Application no: 20/02446/F

Location: Glebe Farm, Boddington Road, Claydon, Banbury

Transport Schedule

DRAWING TITLE: **OFF SITE PASSING PLACE GENERAL ARRANGEMENT AND DETAILS**

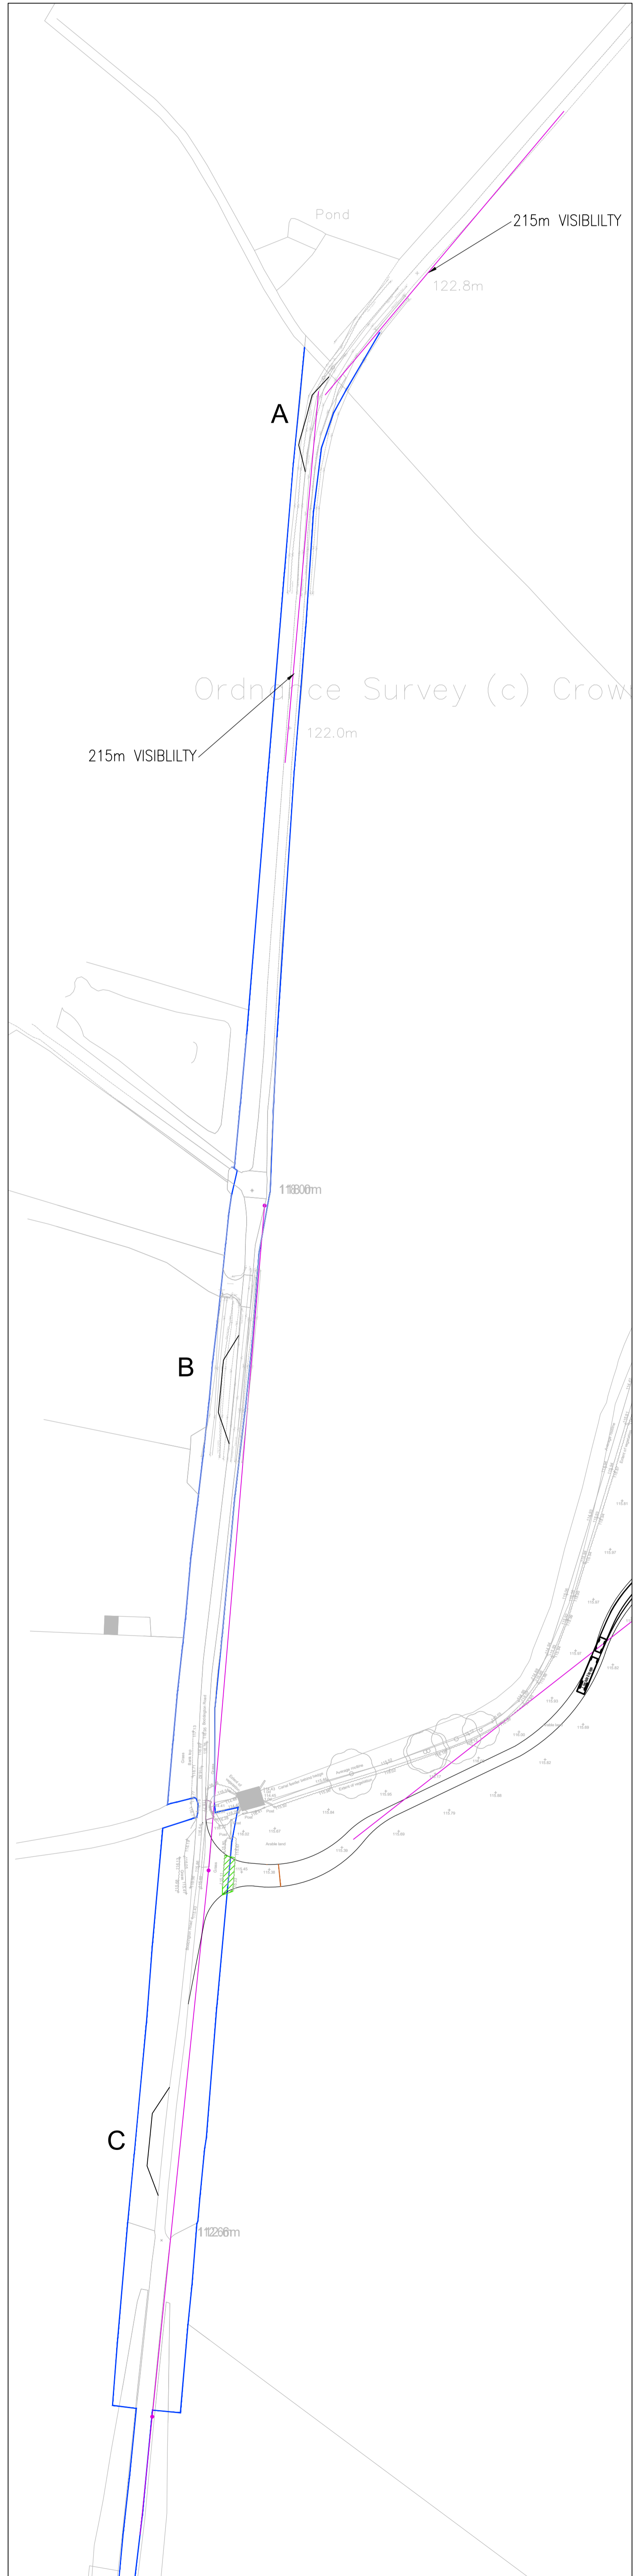
An obligation to enter into a S278 Agreement will be required to secure mitigation/improvement works along Boddington Road by provision of about three passing bays in suitable locations within Oxfordshire County Council jurisdiction.

In order to improve accessibility to the site discussions between the OCC and the applicant agreed that it is reasonable to provide at least three passing places at suitable locations along Boddington Road (within Oxfordshire County's jurisdiction). As such, the applicant will identify areas along Boddington Road for localised widening north of the site that would ensure that safe passage of vehicles in opposite directions can be achieved. This will be subject to a S278 agreement of the Highways Act 1980 secured through a S106 obligations of the same Highways Act.
